# CITY OF ALBUQUE

Planning Department  
Allen Varela, Director

**Re: Escanto Apartments – 5501 University Blvd., SE  
Erosion and Sediment Control Plan  
Engineer's Stamp Date 12/7/2021 (R16D101)**

EROSION AND
SEDIMENT CONTROL PLAN
ENCANTO APARTMENTS
MESA DEL SOL

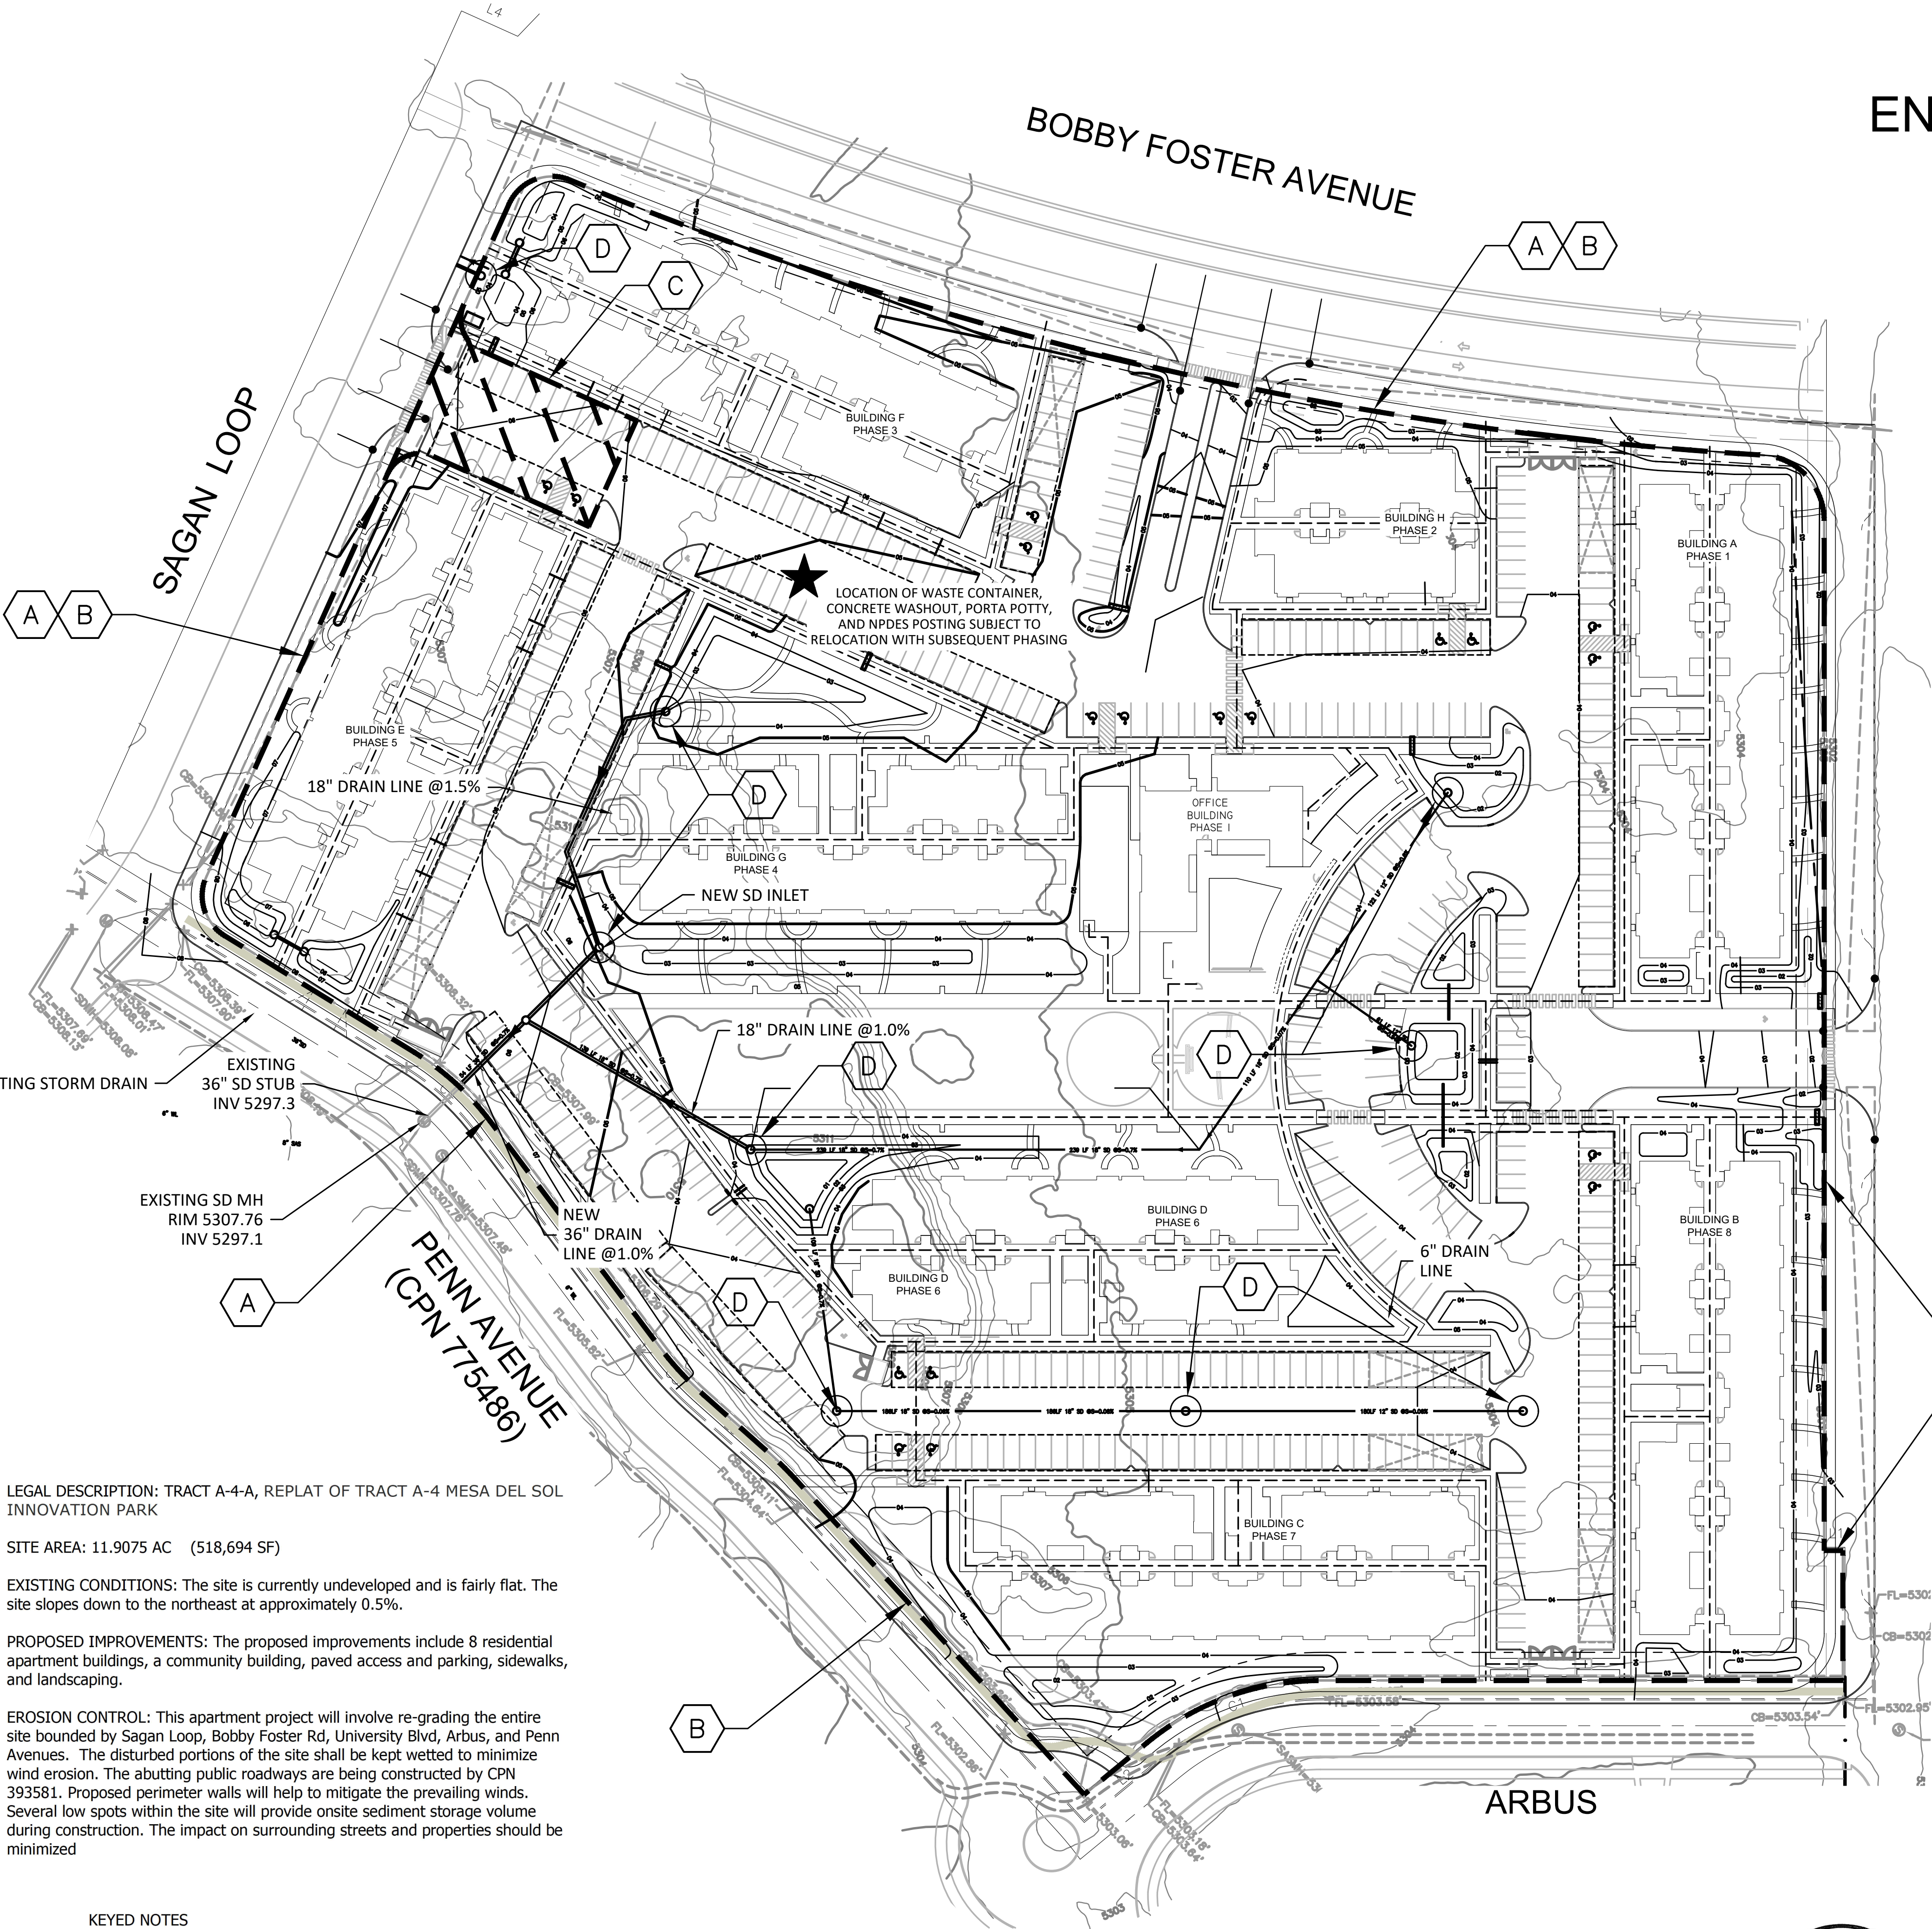
1. The ESC Plan can't be approved until after Hydrology approves the G&D Plan for each specific purpose, Grading, Building Permit, and Work Order. The only purpose Hydrology has approved so far is Site Plan. The existing and proposed grades must be shown on the ESC Plan, and they must agree with the Grading Plan approved by Hydrology (CGP7.2.4.b.ii);

3. Add a legend to the plan and show the location of the limits of land disturbing activities. Also show symbols and line types in the legend and in the precise location of BMPs silt fence, inlet protection, waste container, concrete washout, porta potty, and NPDES posting (CGP7.2.4.b.i);

7. I can't tell the difference between building, sidewalk, asphalt, and dirt on the ESC Plan. These structures must be clearly identified in the SWPPP per CGP 7.2.4.b.v. The same information is required in the ESC Application. You may include a copy of the Site Plan in both the SWPPP and in the ESC Application to address this requirement.

8. Stabilization measures (CGP 7.2.6.b.vi), including a) **Specific** vegetative and non-vegetative practices, b) deadlines. The landscape plan can be used to satisfy this requirement and should be included in the SWPPP and the ESC Plan submittal;
